Summary of Submissions and Proponents Response (20/01/11)

June 22nd 1500

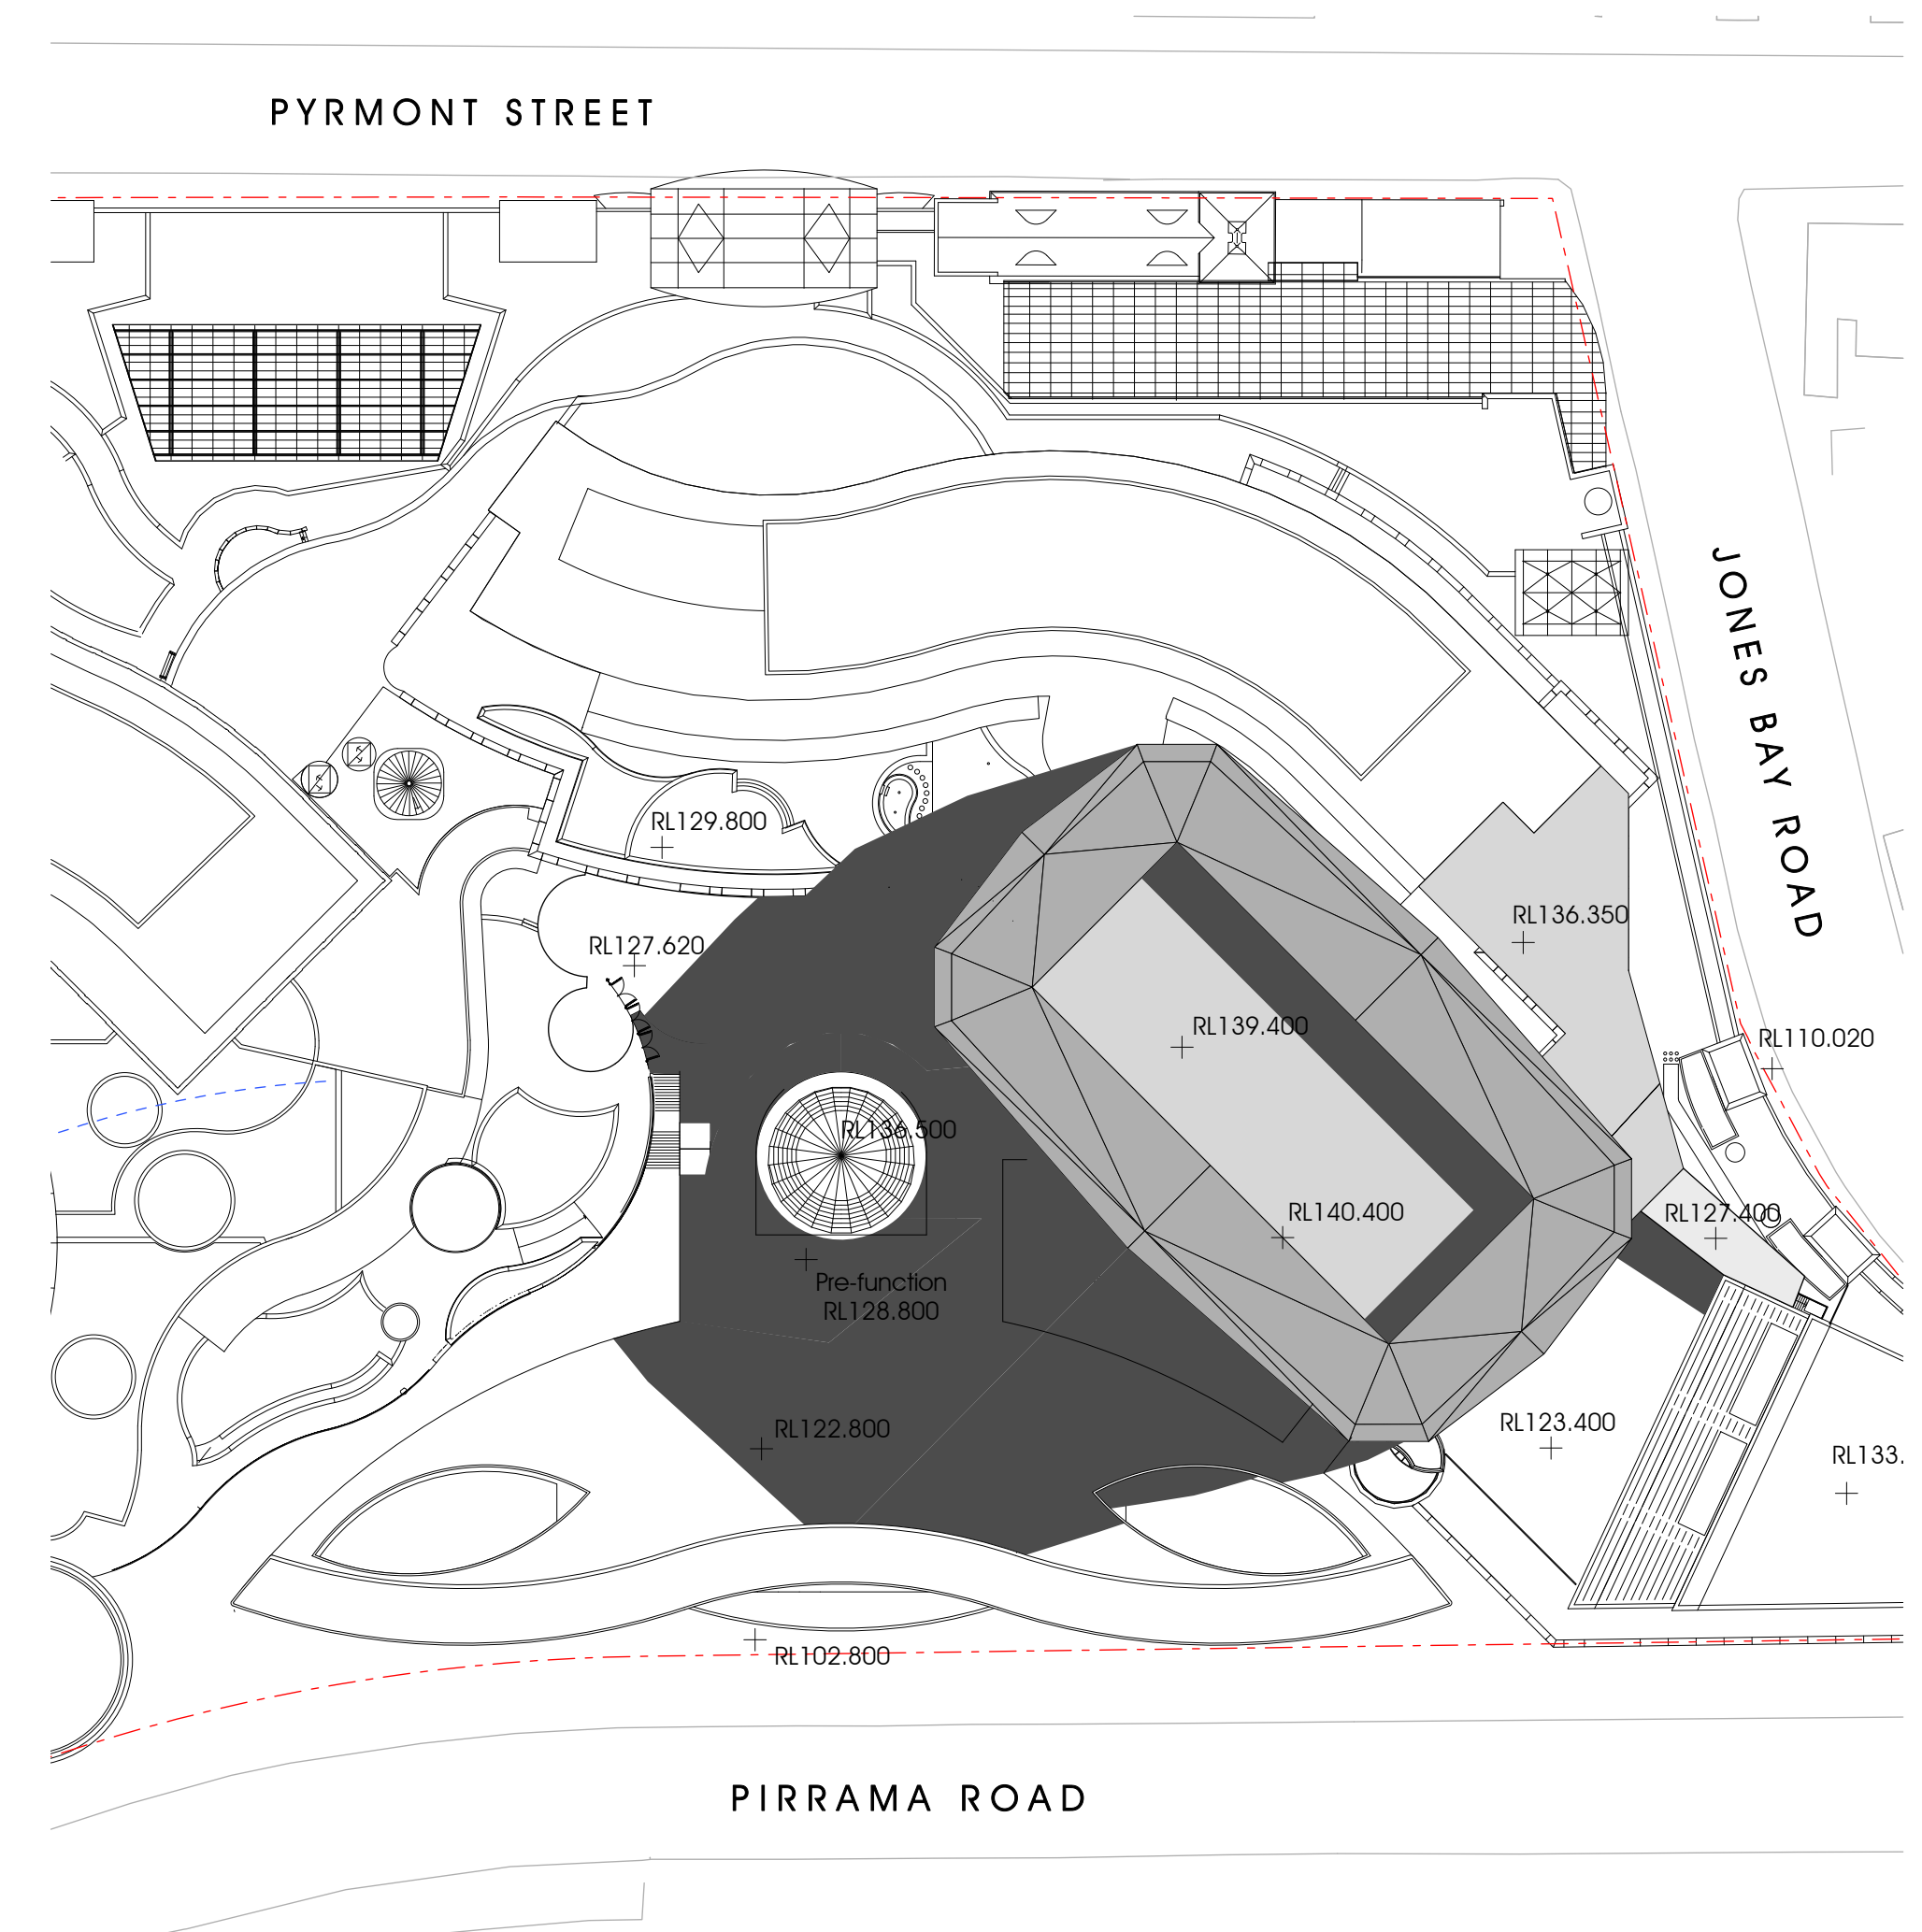
<p>Robert Wirth, Warwick Saunders, Zena Vaasssen, Stafford Van Putten 14 & 16 Pymont St, Pymont 11/12/10</p>	<p>Proposed development will adversely affect the quality of life for residents of 14, 16 and 18 Pymont Street (as well as the Watermark Building). The increased height will result in loss of already limited sunlight access to the rear of these properties. The issue of loss of light and its impact on the community has not been addressed by the Casino developers.</p>	<p>These properties are located towards the north-west of the MUEF. Submitted shadow diagrams illustrate that the MUEF will not cause overshadowing to these terraces.</p>

Cross Section A-A Revised
F+P JW 17/01/11

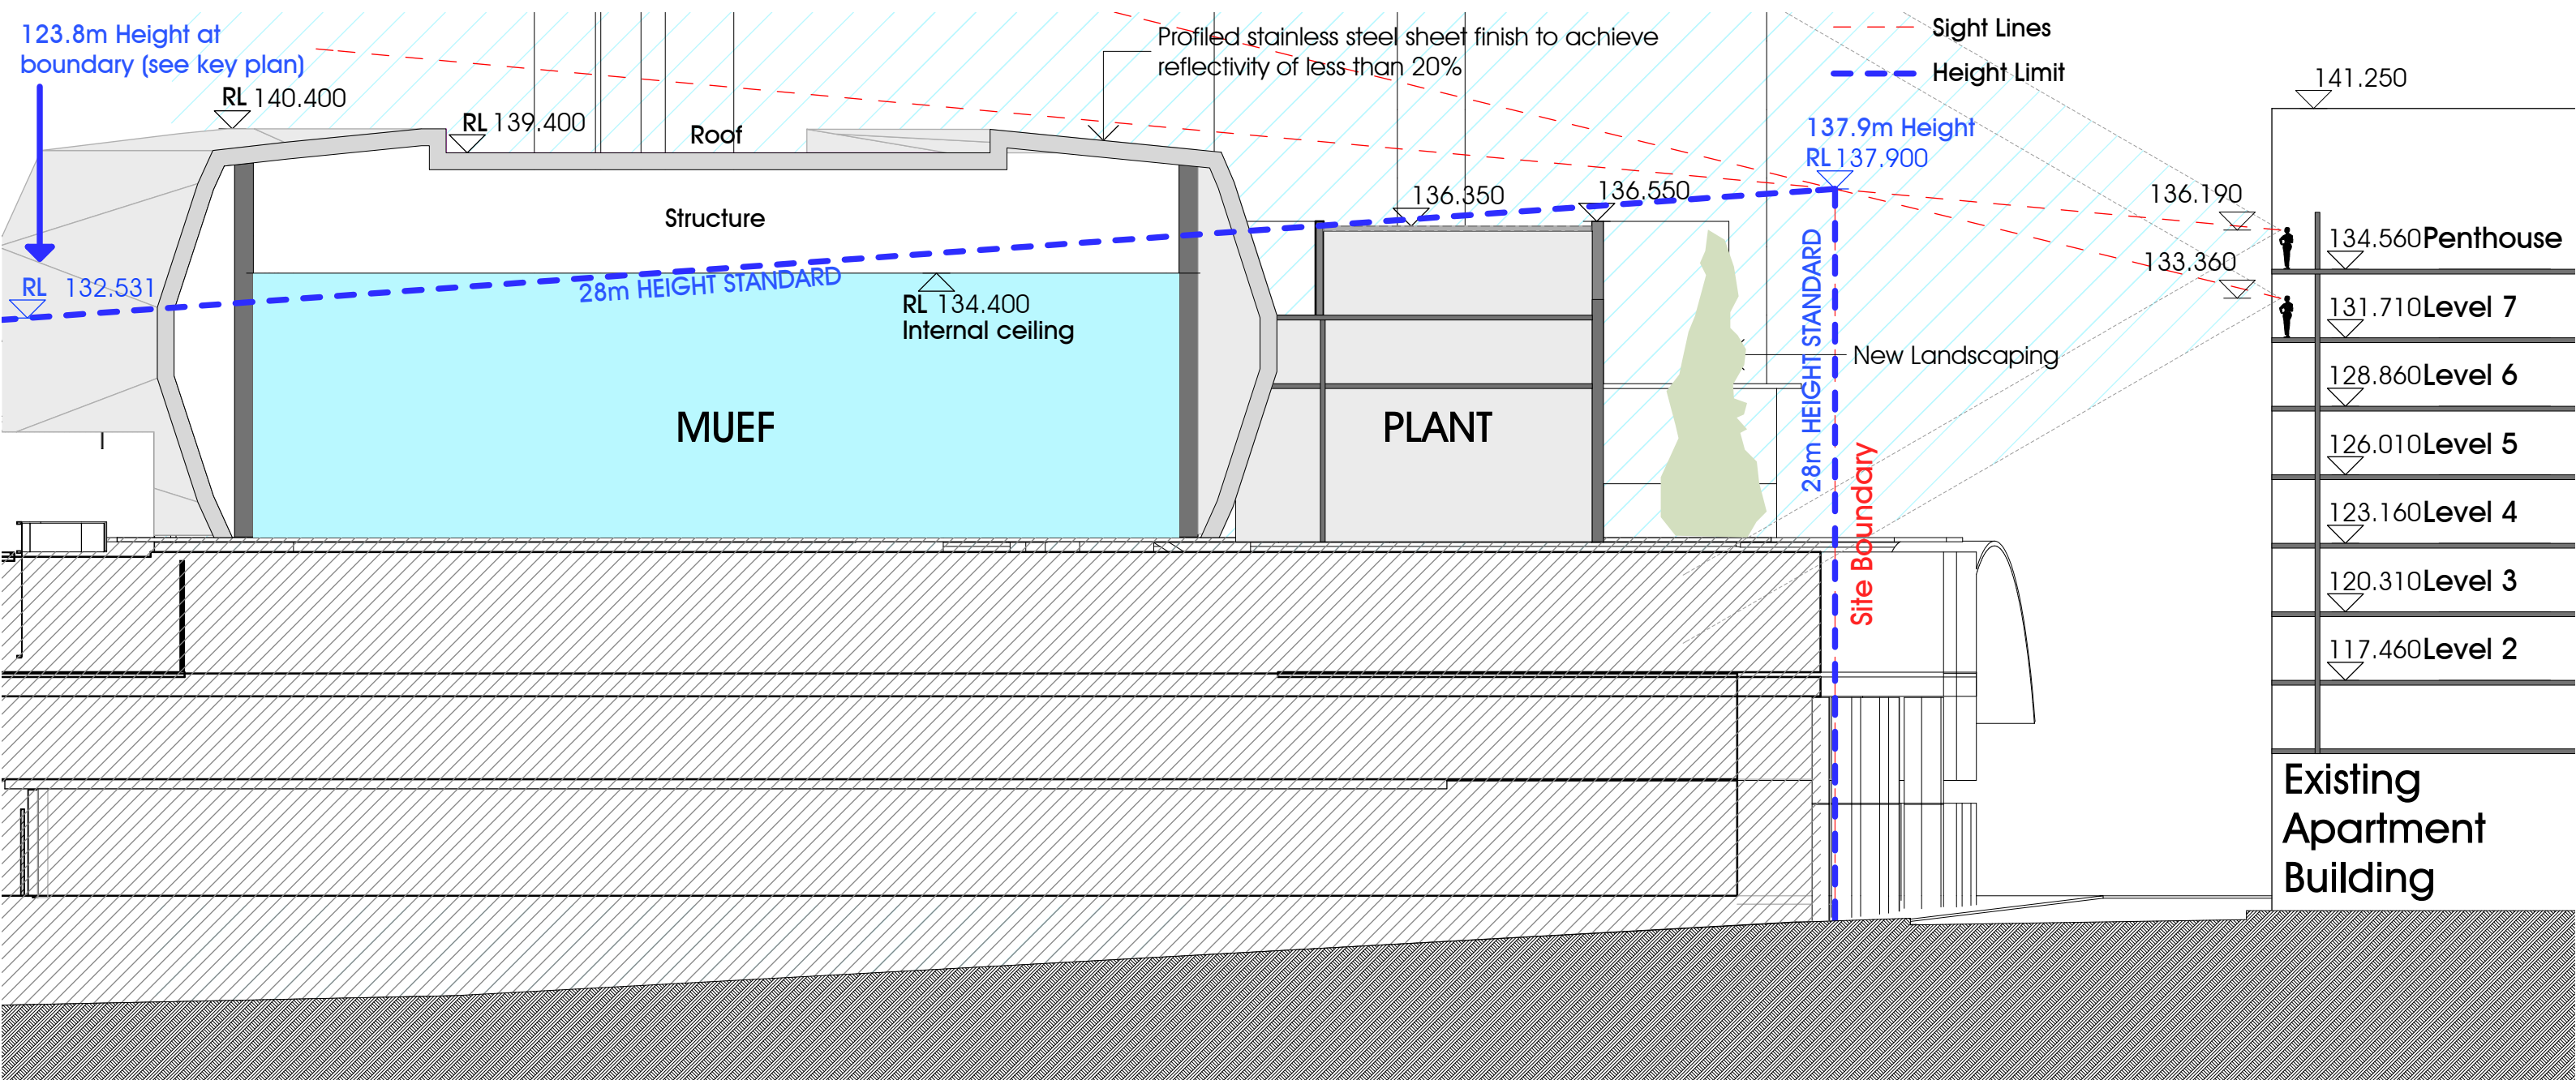
<p><i>Construction Noise</i></p> <p>The acoustic report submitted states that noise is likely to exceed the criteria by 11dBA on Jones Bay Road. Some mitigation measures are proposed, however, it is considered that a more robust response to minimising potential impacts to nearby residents is required. It is recommended that a condition be imposed requiring a 'Construction Noise Management Plan' specific to the proposed works prior to any works commencing.</p>	<p>Construction noise will be managed and minimised as much as possible. A construction noise management plan can be prepared prior to commencement of construction of the MUEF.</p>
<p>Tim Mancuso</p> <p>706/2 Jones Bay Road</p> <p>Pymont</p> <p>19/11/10</p>	<p>Impact on residents in Watermark building – loss of views and associated financial losses. Scale of the development is overbearing and unnecessary.</p>	<p>The revised Visual Impact Assessment (VIA) provides the following assessment relative to private view loss:</p> <ul style="list-style-type: none"> ▪ Levels 3 to 6 will be affected, and would be affected by a fully compliant development. ▪ With respect to Levels 7 and 8, as the floor level of the balcony is below the height of a 28m plane at the frontage of the site, the sightline from Level 7 and 8 to this plane is

AGENCY SUBMISSIONS		
Agency	Issues or Comments	Response
		<p>elevated from the horizontal such that it extends above the proposed MUEF structure, notwithstanding that the MUEF structure is higher than the height plane (Refer to the section drawing on page 8 of the VIA). Furthermore, the 28m height line regulates ceiling level and provides for roof structures and plant areas above. In this regard, we note that the proponent's assessment of visual impact of the MUEF structure considers all parts of the building and not just the ceiling height and can therefore be considered conservative.</p> <ul style="list-style-type: none"> Overall, the proposal maintains the existing water glimpses and the view of the Centrepont Tower and the MLC Building from Level 8. The retained view corridor available still delivers the iconic western elevation of the city skyline, which is also the case for Level 7. <p>Refer to the VIA for further assessment (Appendix D).</p>
